CITY OF ALBUQUERQUE

Re: 124 Kappa Office
124 Wellesley Dr. SE
Traffic Circulation Layout
Engineer's/Architect's Stamp 12-11-18 (K16D088)

Based upon the information provided in your submittal received 12-11-18, the above referenced plan cannot be approved for Building Permit until the following comments are addressed:

TRAFFIC CIRCULATION LAYOUT SITE PLAN (TCL)

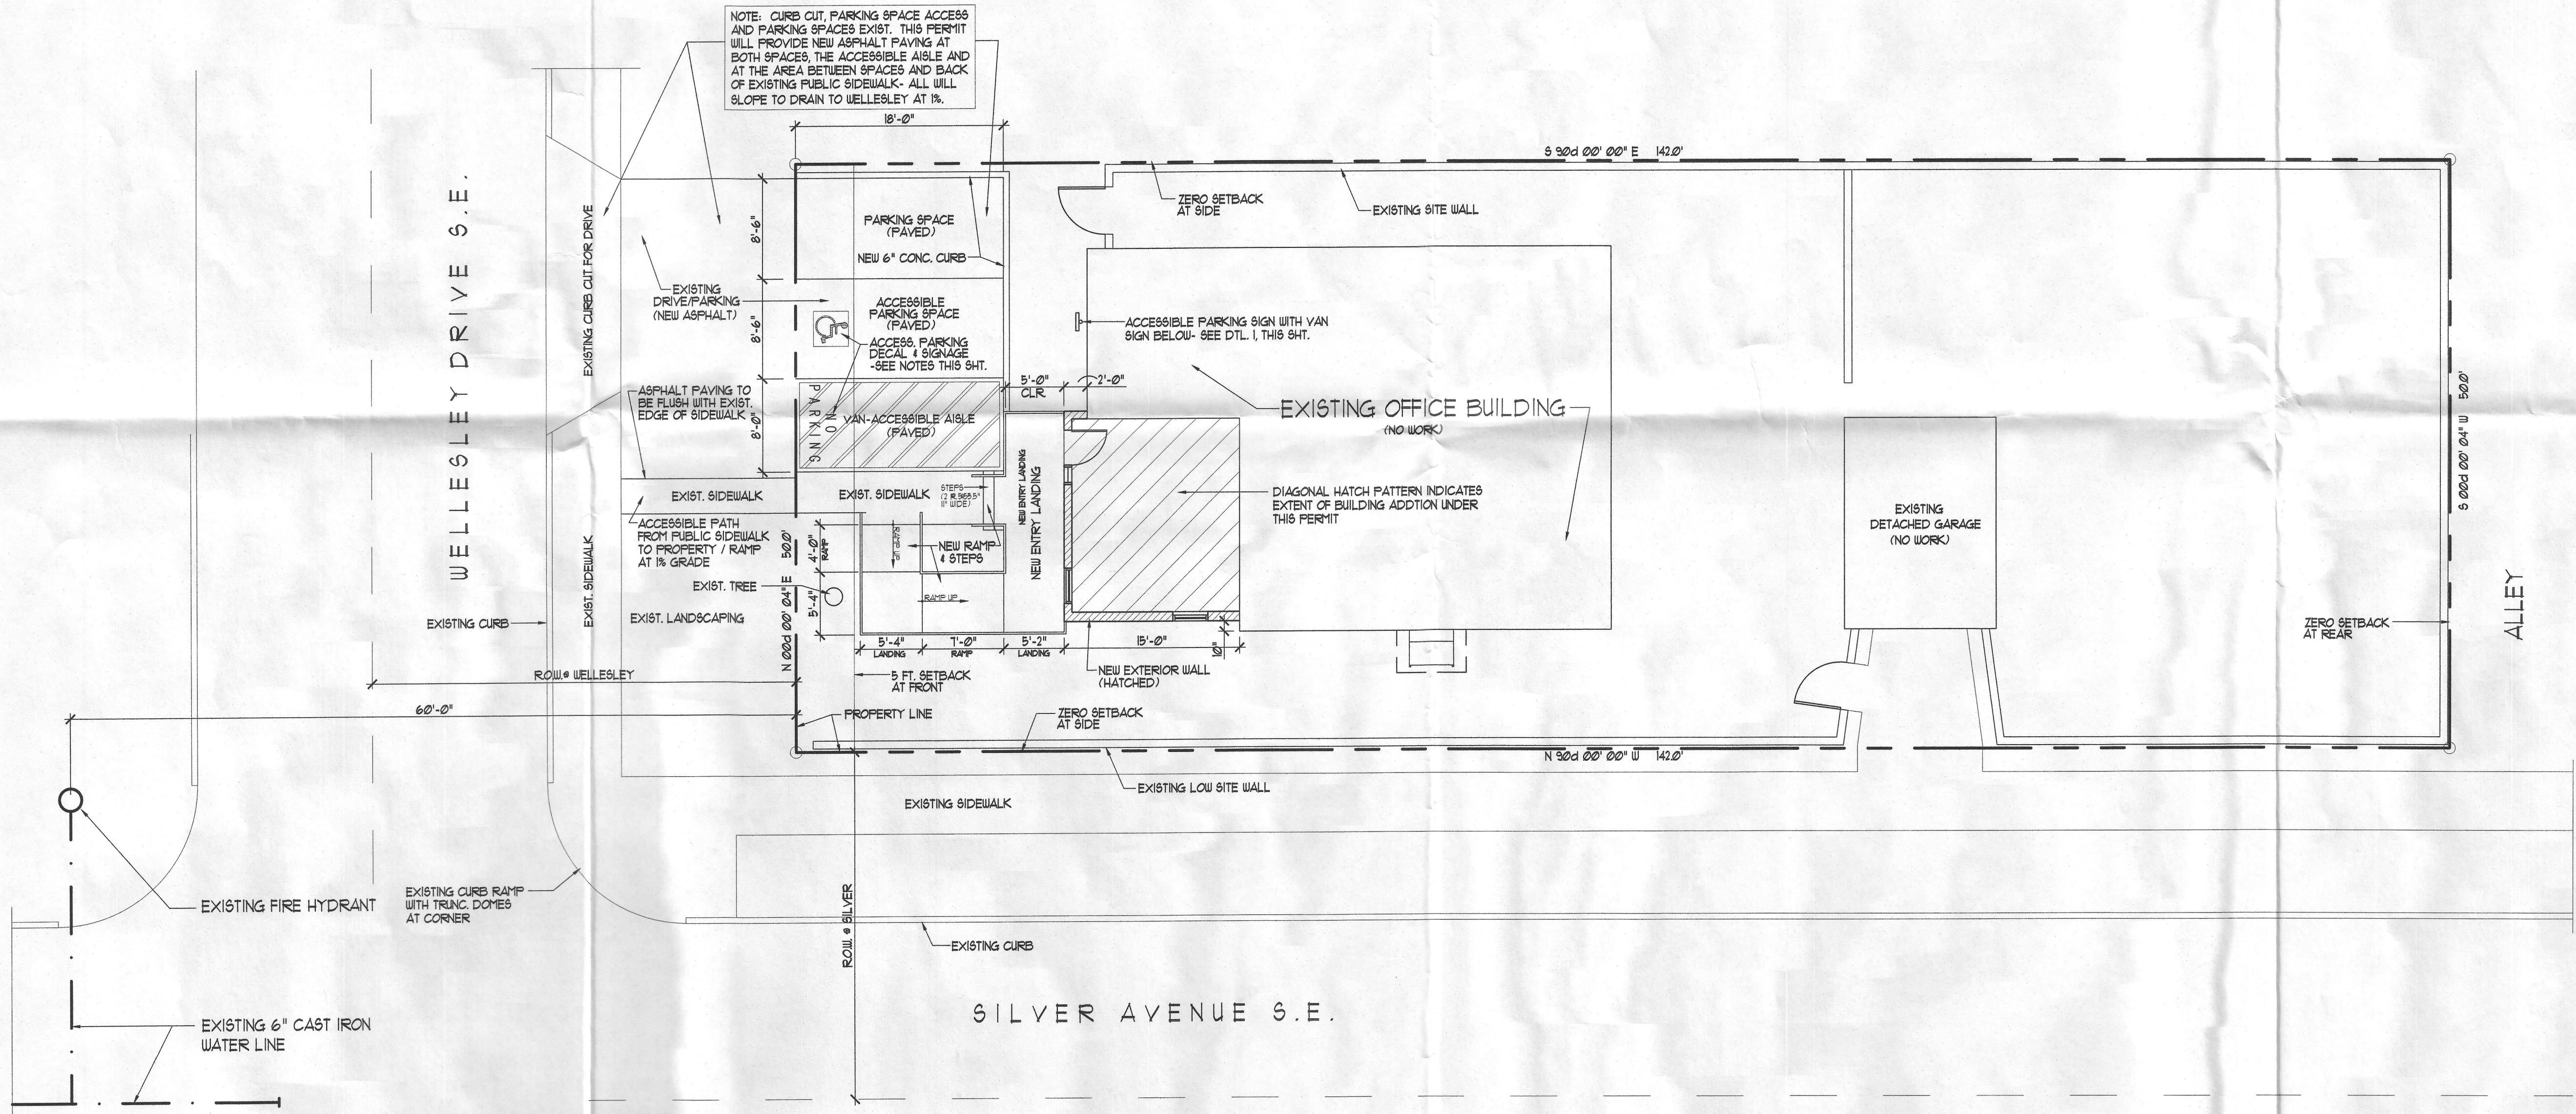
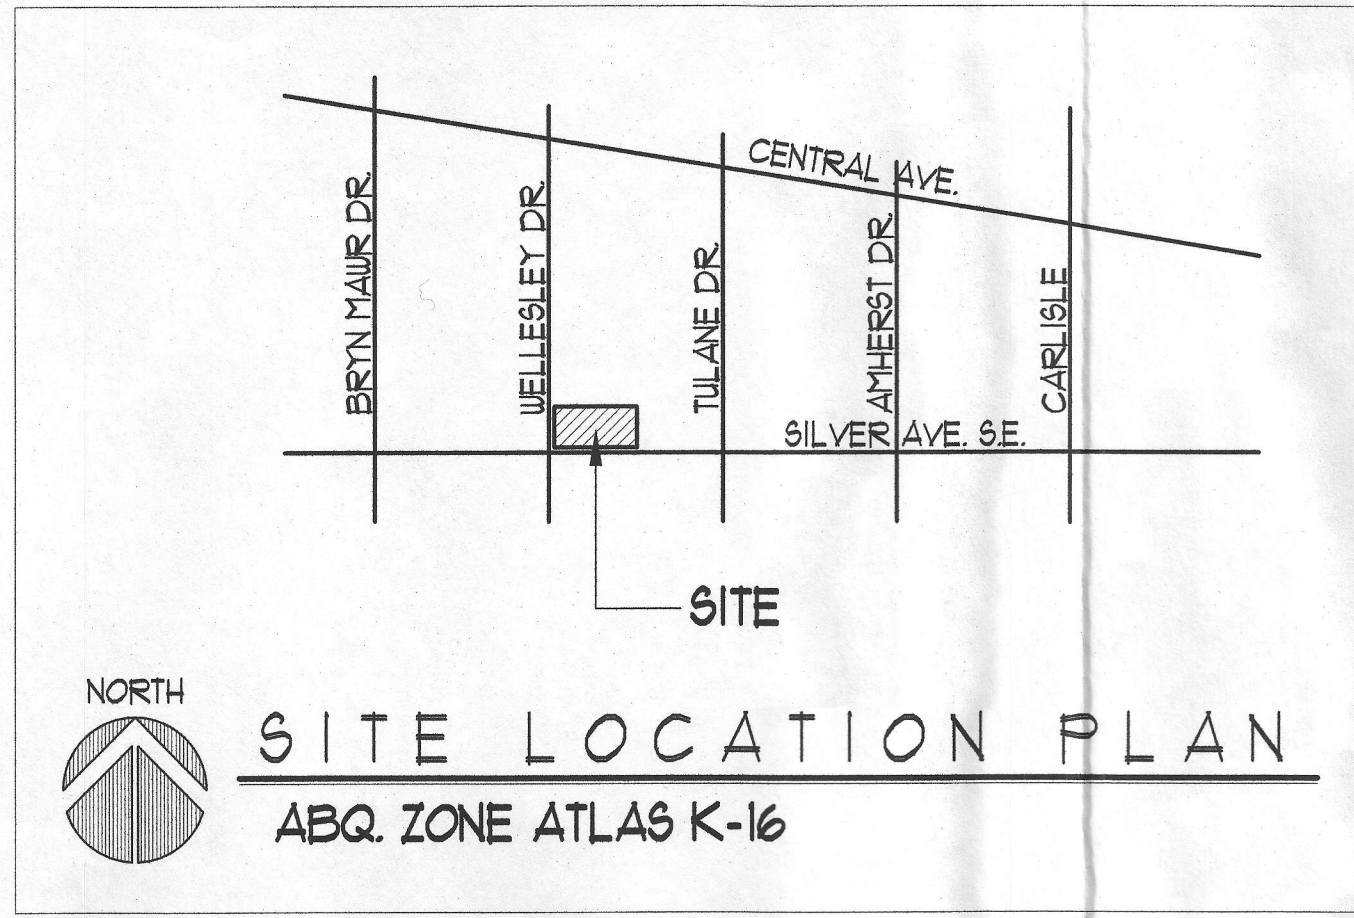
1. The ADA accessible parking sign must have the required language per 66-7-352.4C NMSA 1978 **"Violators Are Subject to a Fine and/or Towing."** Please call out detail and location of HC signs.

2. The ADA access aisles shall have the words **"NO PARKING"** in capital letters, each of which shall be at least one foot high and at least two inches wide, placed at the rear of the parking space so as to be close to where an adjacent vehicle's rear tire would be placed. (66-1-4.1.B NMSA 1978)

3. Per the IDO, a 6 ft. wide ADA accessible pedestrian pathway is required from the public sidewalk to the building entrances. Please clearly show this pathway and provide details. (Commercial or multi-family development requiring 5 or fewer parking spaces shall provide a minimum of 4-foot walk path) (Existing 3 foot walk path can remain if asphalt is flush with walk path)
